Application no: H18/0592/95

Description: Proposed new clubhouse

Amendment: Change of landscaping  
(Drawing No.s 228/5/2, 228/5/3B & 228/5/4B)

TOWN AND COUNTRY PLANNING ACT 1990  
NOTICE OF ACCEPTANCE OF AMENDMENT

Dwg No 228/5/4B Scale 1:1000

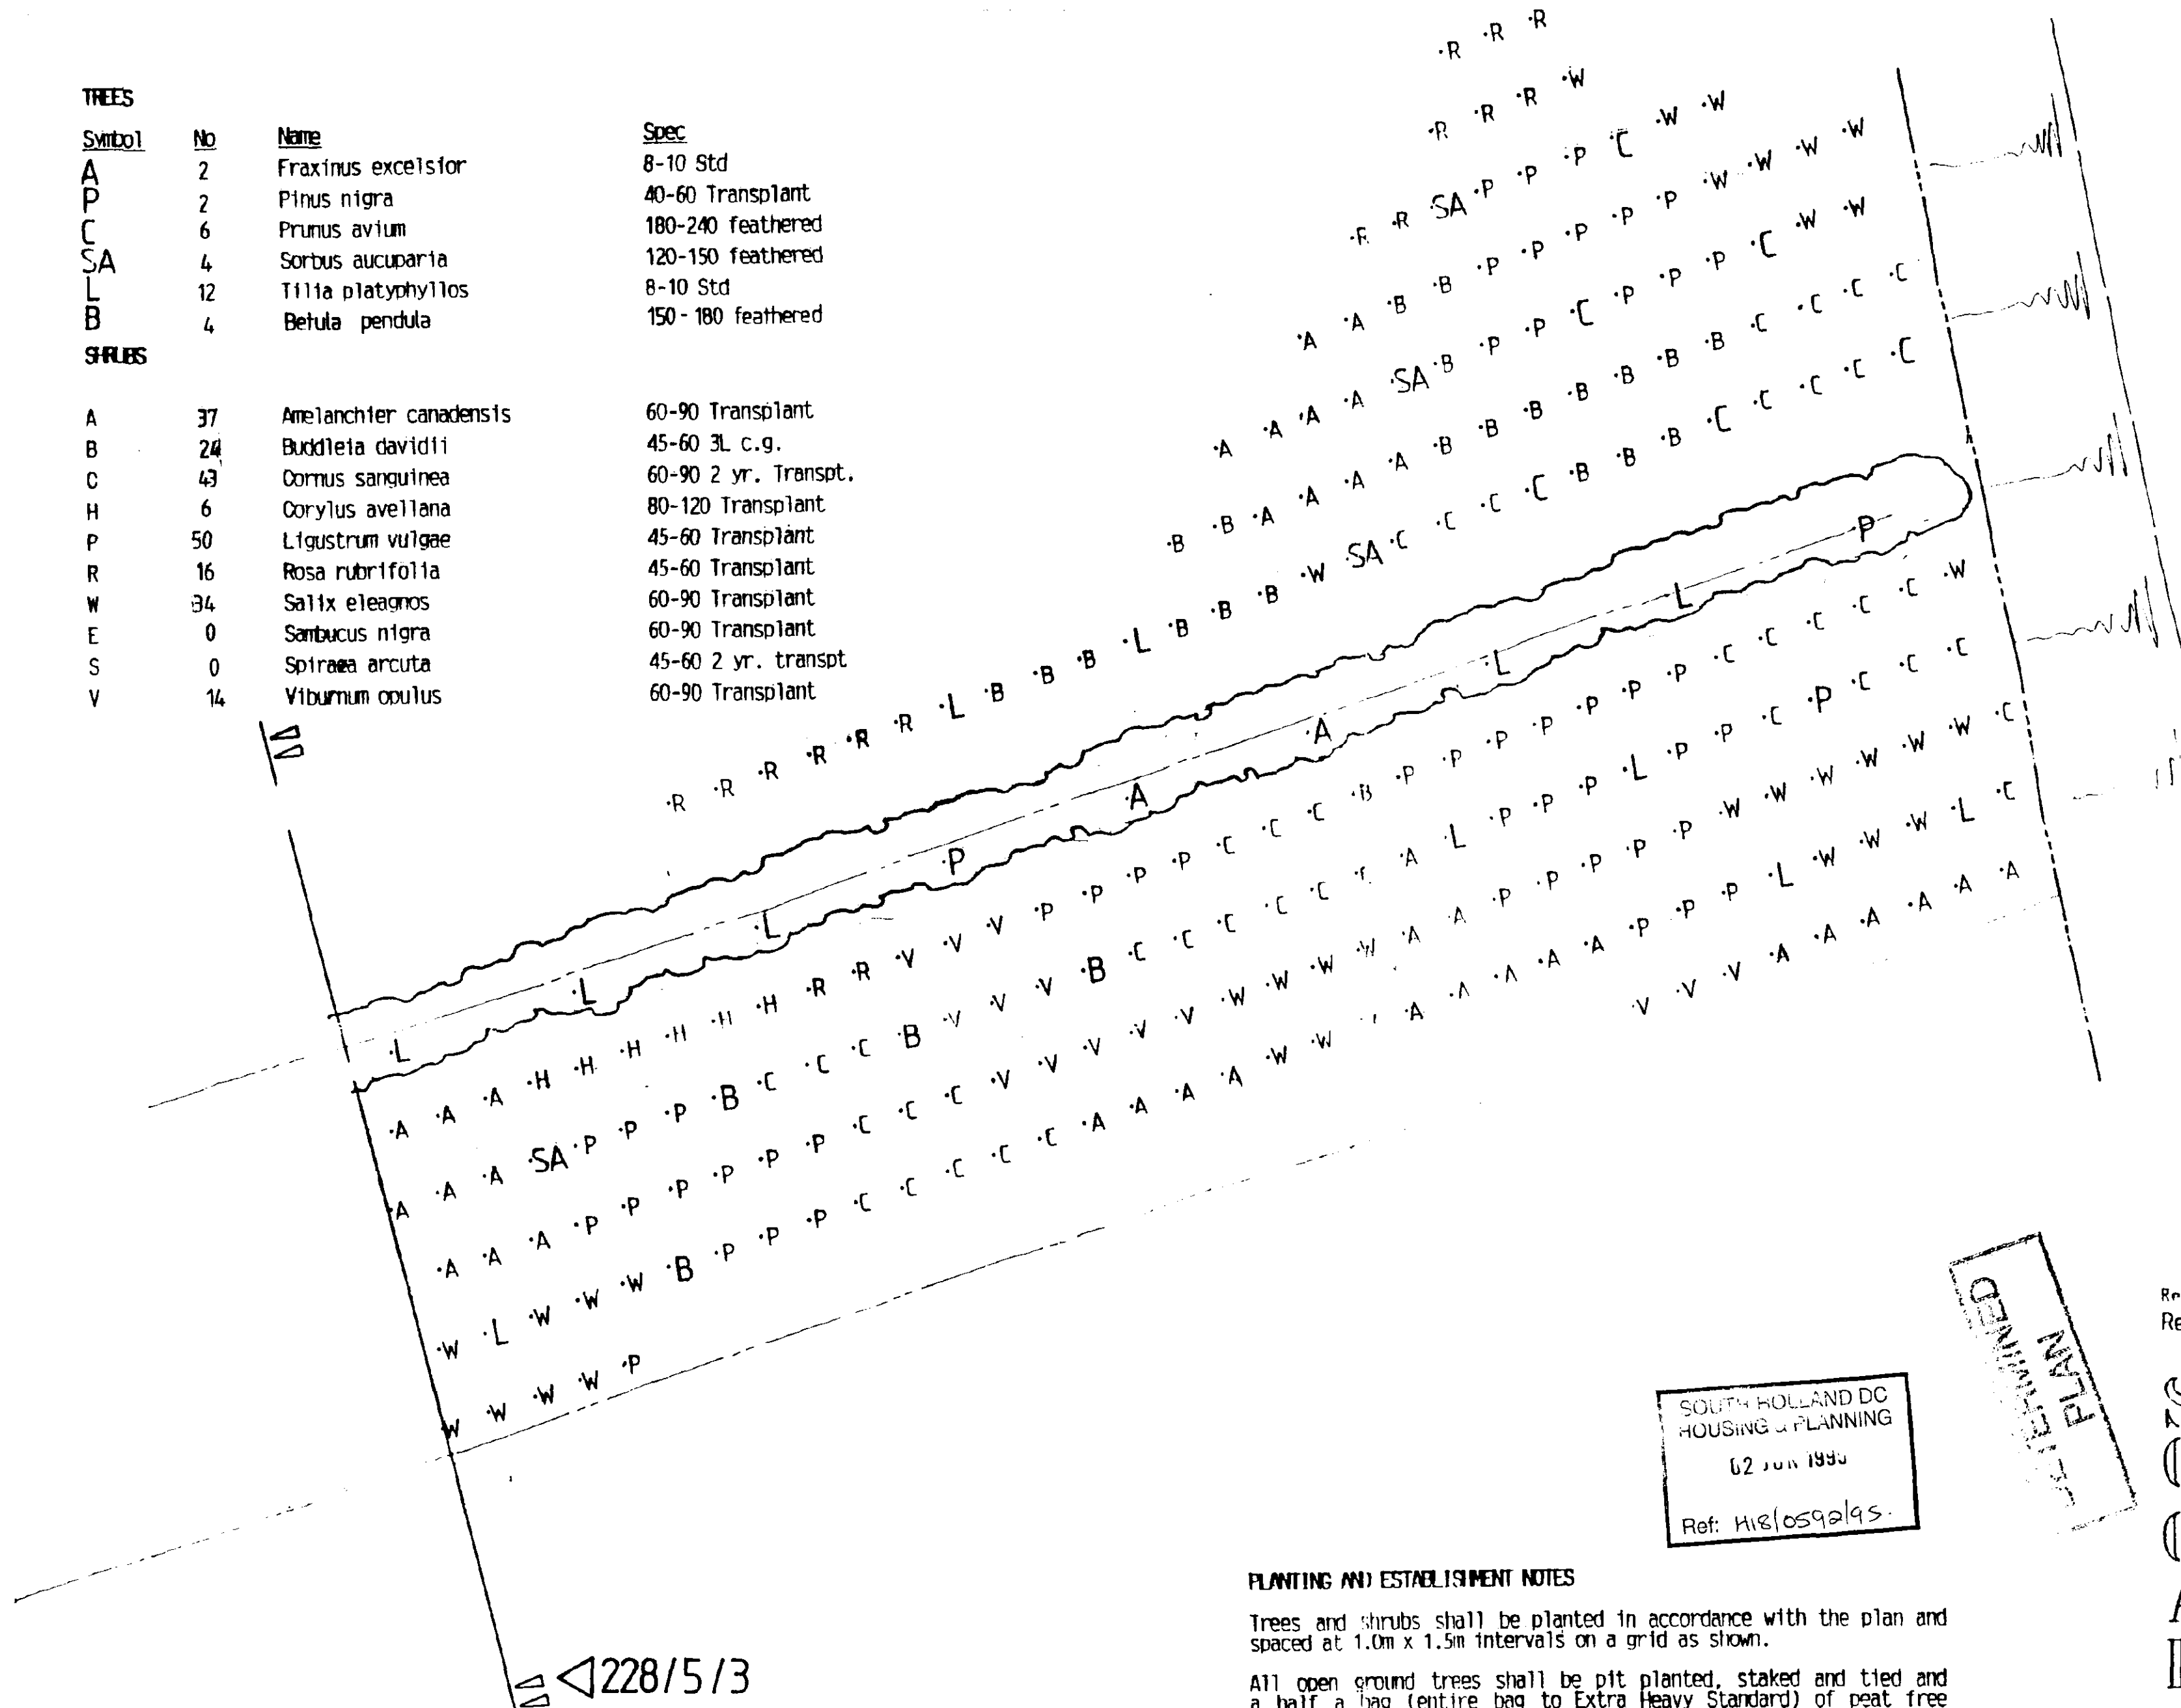
changes in landscaping details  
- plan 228/5/2, 228/5/3B &  
228/5/4B repl - change in size of  
some trees, as marked on accompanying  
plans, a deletion of requirement for 66sq  
228/5/2, 228/5/2B, 228/5/4B.
